I strongly object to the approval of SSD 7056. Please see my three original submissions regarding the issues it poses. The applicants' recent responses (May 2016) show that they have done little to address these and worse still, that at least some of their consultants, have not considered them worthy of a response. The submission which follows is my specific response to this amended SSD application.

The amended application retains the same misleading title, 'Remediation, Restoration and Adaptive Re-Use of Campbell's Stores'. It thus continues to hide the fact that a significant part of the proposal relates to a proposed new four-storey-high building in a space that earlier decision makers determined should be left vacant or, at the most, allow a sun protection

Drawing Title  
**ELEVATIONS**  
JPW Project Number  
12006  
Drawing Status  
EA  
Drawing Number  
EA-A-2000  
Revision  
B

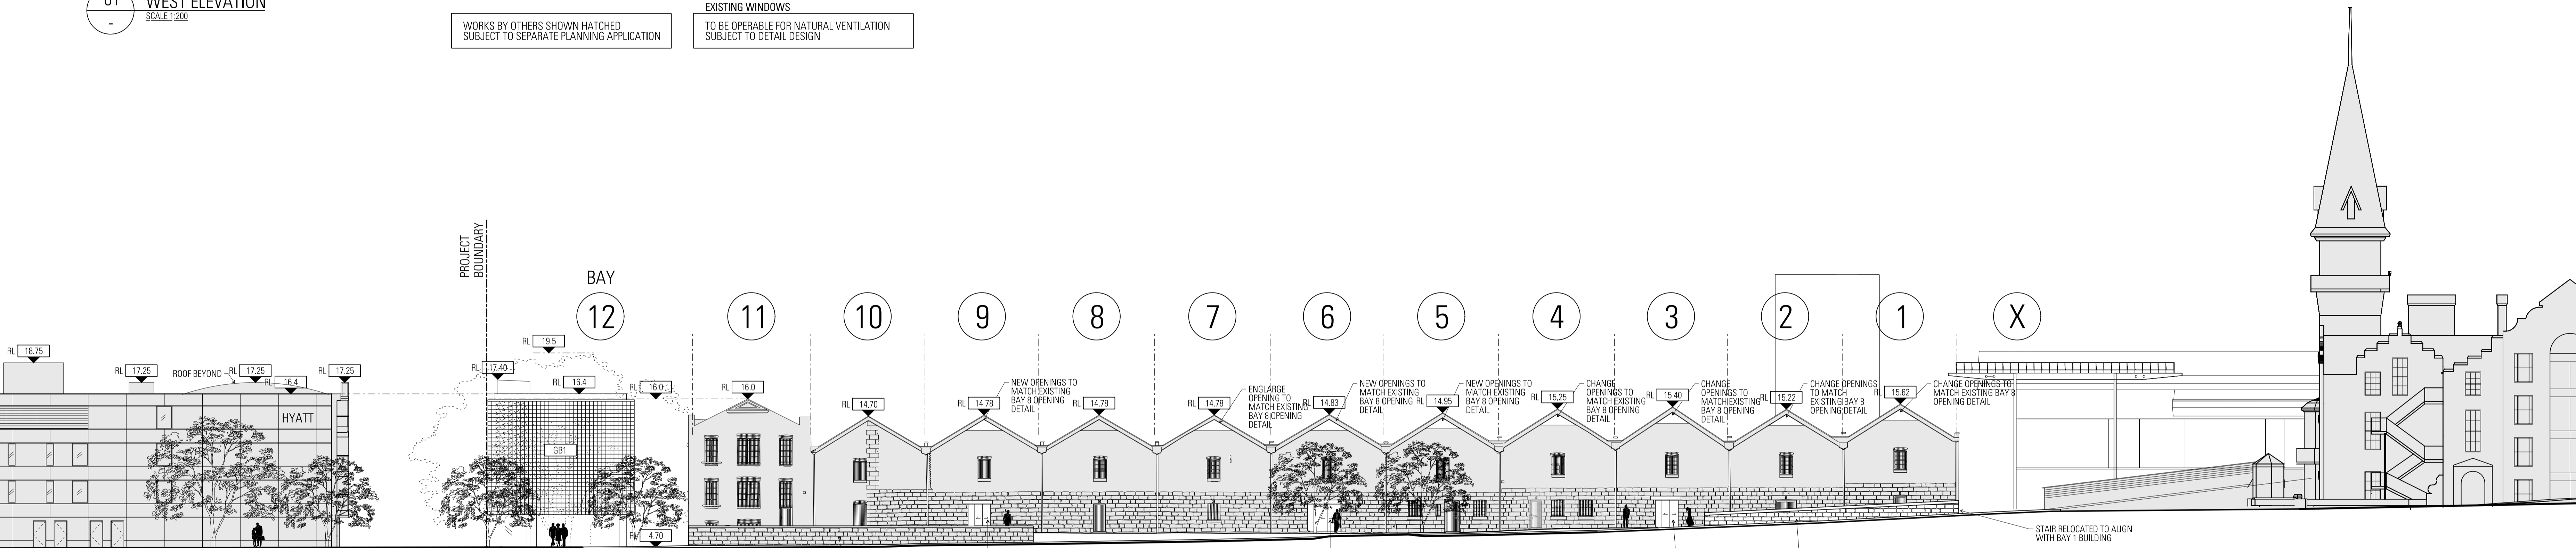
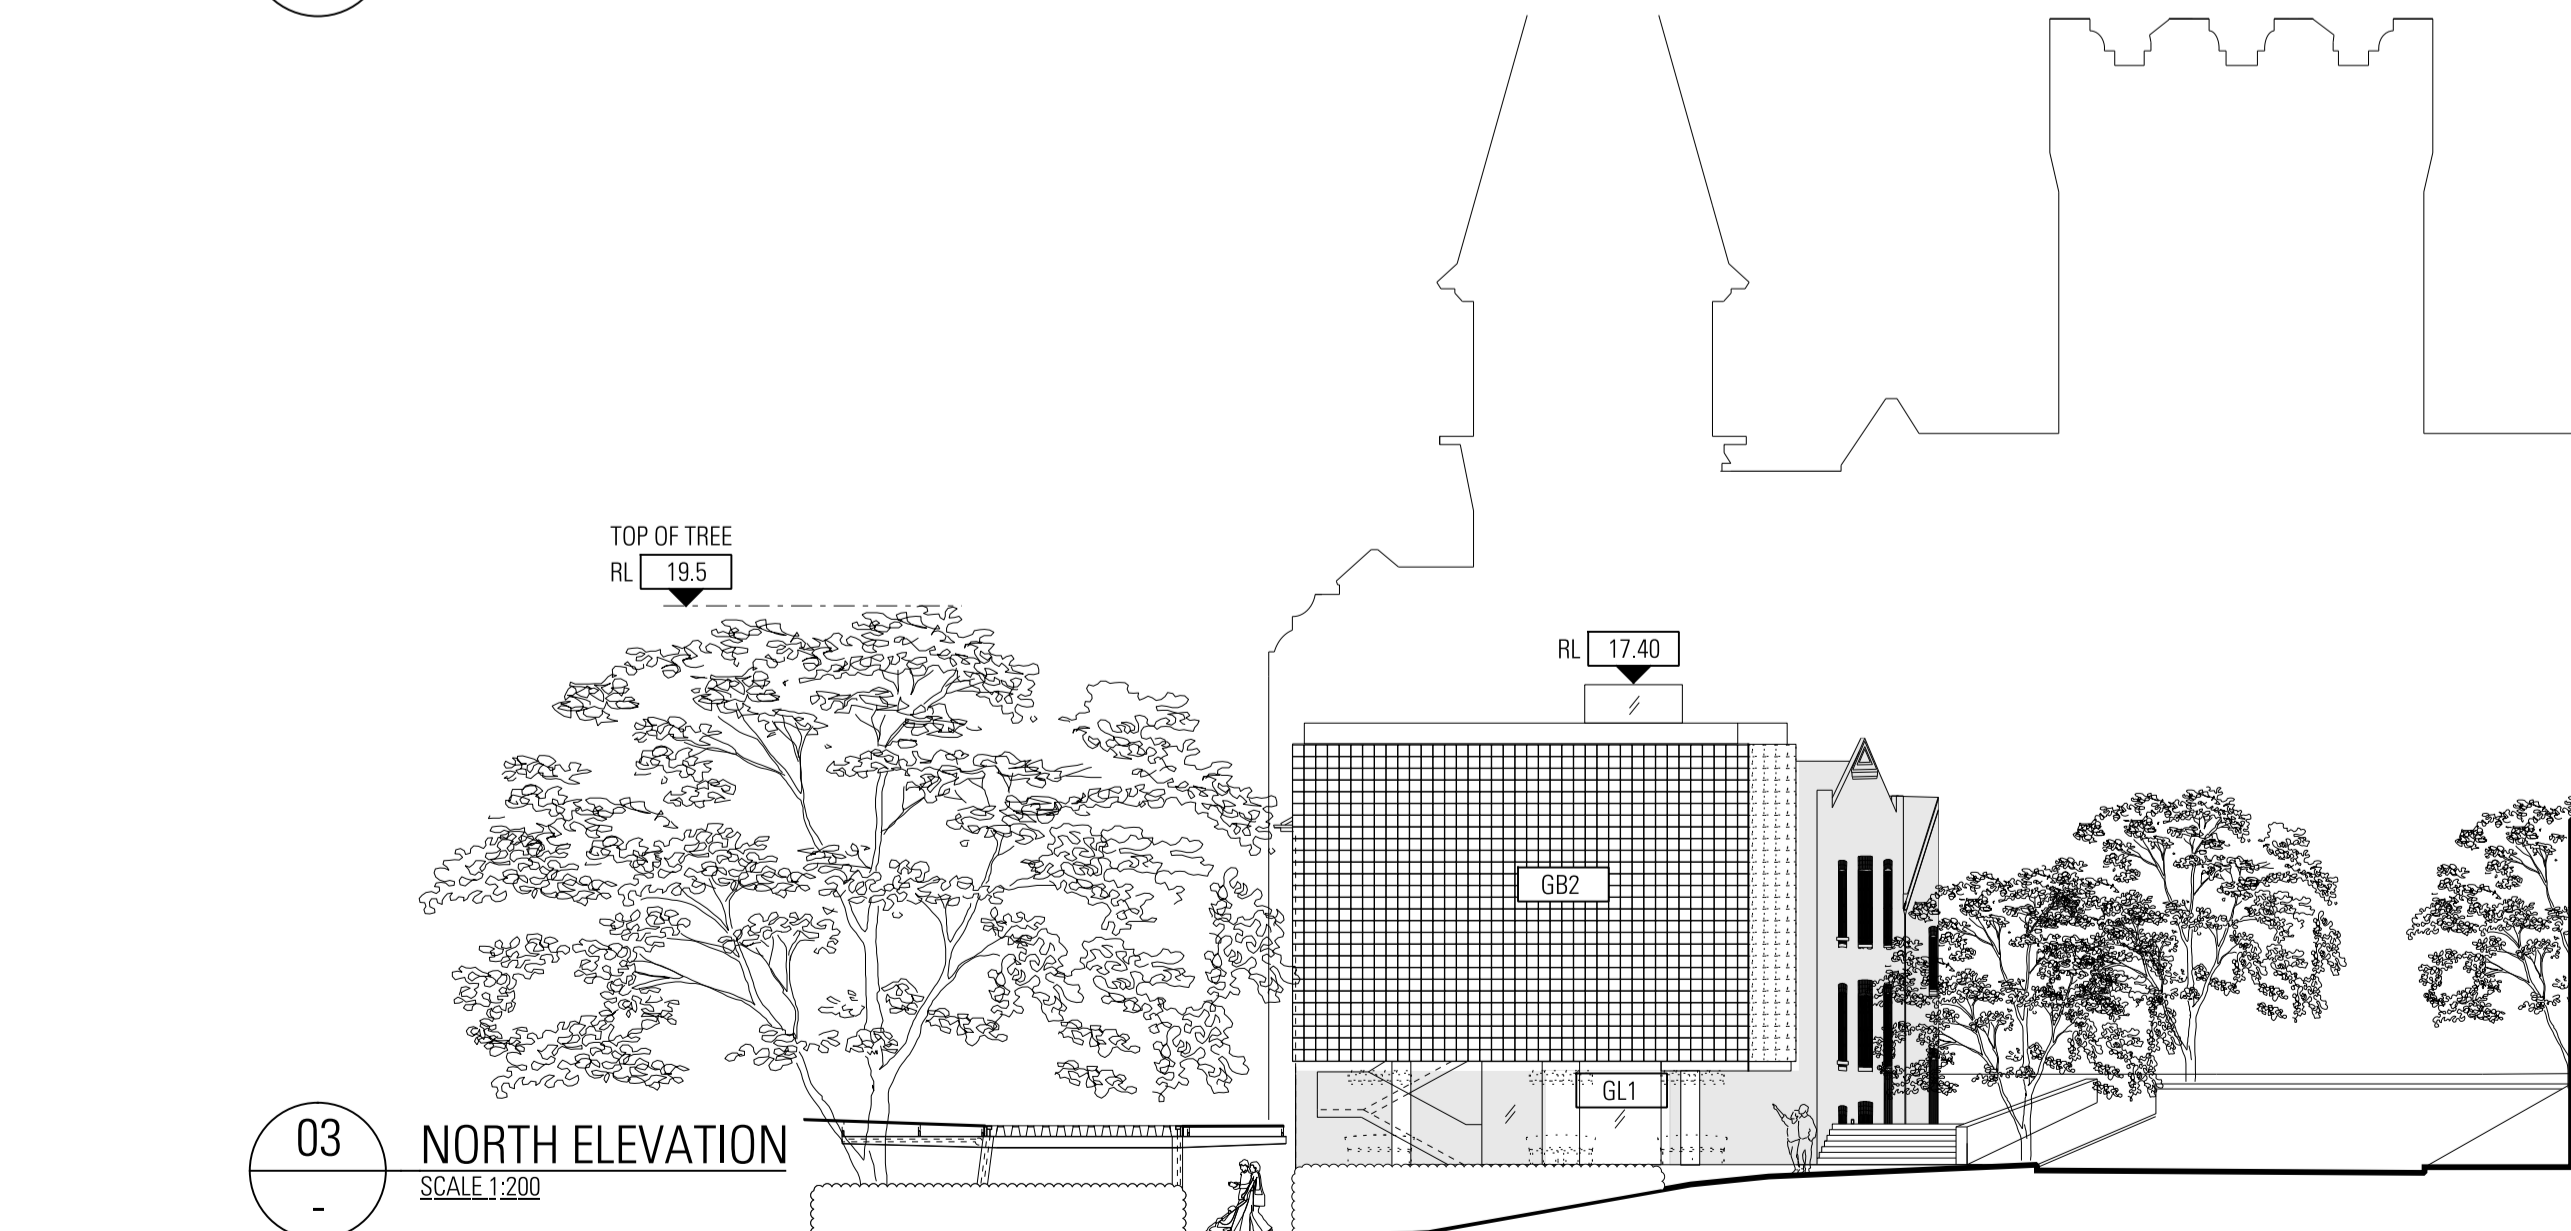
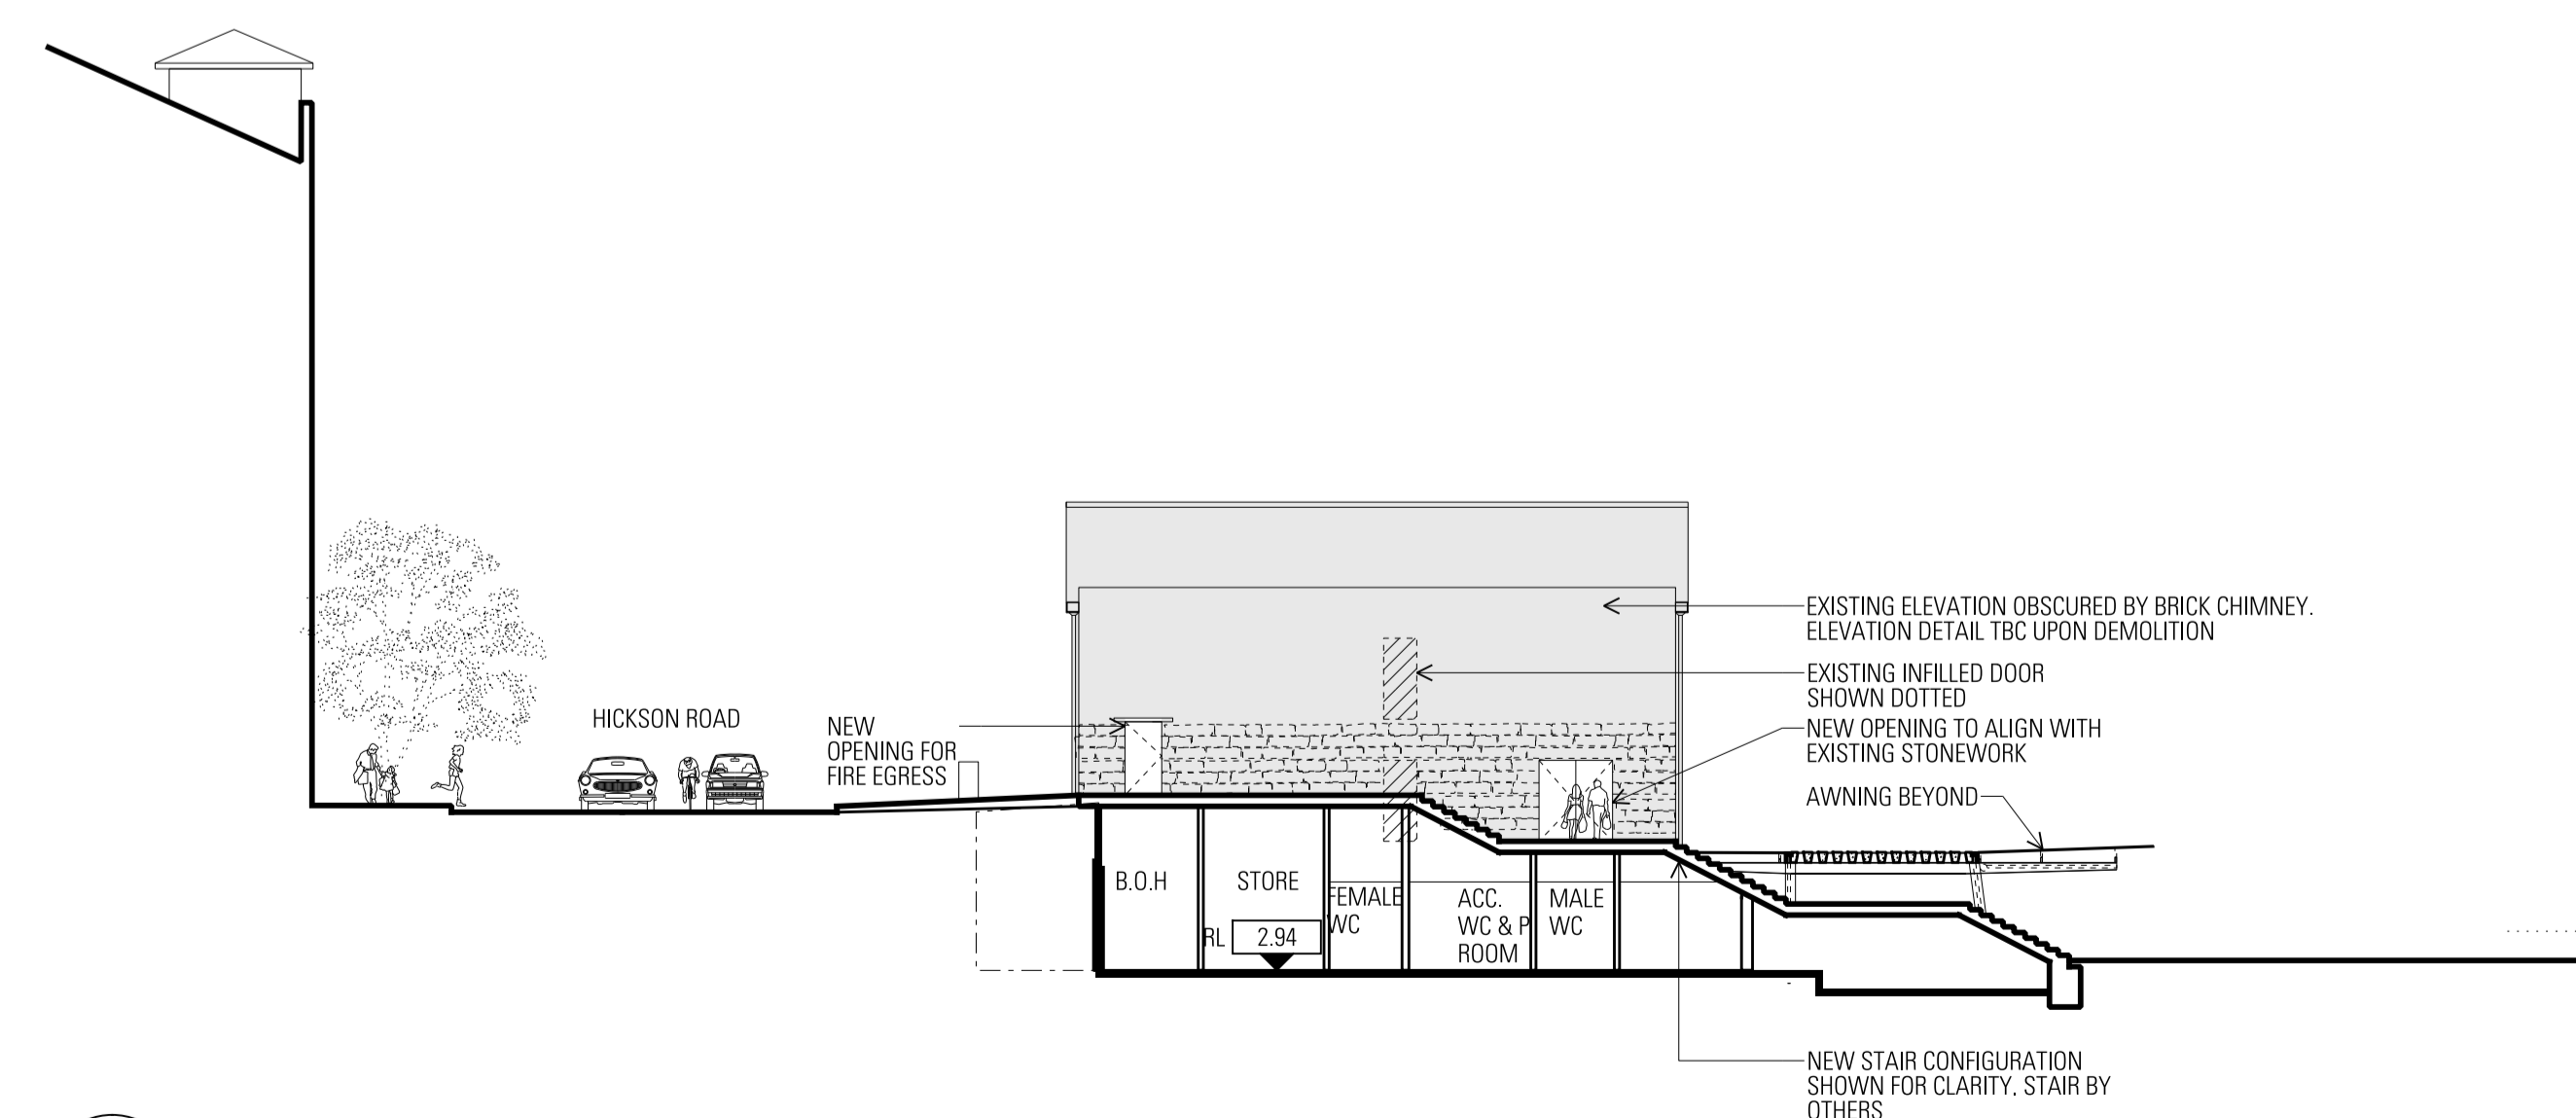
The 'glass box' is the worst of the applicants' proposals and the amended SSD application does little to address criticisms of it. Effectively a bulky glass box on stilts, the proposed new building, even with its reduced height, would still dominate the Hickson Rd streetscape and the Campbell's Cove foreshore. It would have no visual or aesthetic relationship with Campbell's Stores on one side of it or the sympathetic, modern lines of the Park Hyatt Hotel on the other. It would look like it had been parachuted in and create a sense of crowding and over-development in what was intended as open space. The applicants' images misleadingly depict the building as transparent; in reality you wouldn't be able to see through it at all.

The glass box would be a dominant, unattractive addition to the heritage foreshore. This is clearly shown in Figure 13, p.35 of the 'Response to Submissions' and in Figures 6.13, 6.15 and 6.16 of p.25 of the Appendix B1 Design Response Report, Part 3. The box would create an impression of density and scale out of keeping with The Rocks' character and a sense of overdevelopment by restricting the rhythm of space to built form along both the foreshore and the Hickson Rd streetscape. To accommodate this rhythm, it should be no higher than the gutter level of Bay 11 and two metres narrower, but even then it would be out of place here.

What the drone images do demonstrate is the extent to which the proposed new building is at odds with Hickson Road’s heritage streetscape and colour palate. The glass box would not be transparent as shown. It would be bulky and dominate the Stores’ building. This is in marked contrast to the view of Campbell’s Stores I now enjoy, where what predominates is its gabled bays, saw-toothed roofline, repetition of door and window openings and its simple, warehouse functional, 19th century architecture.
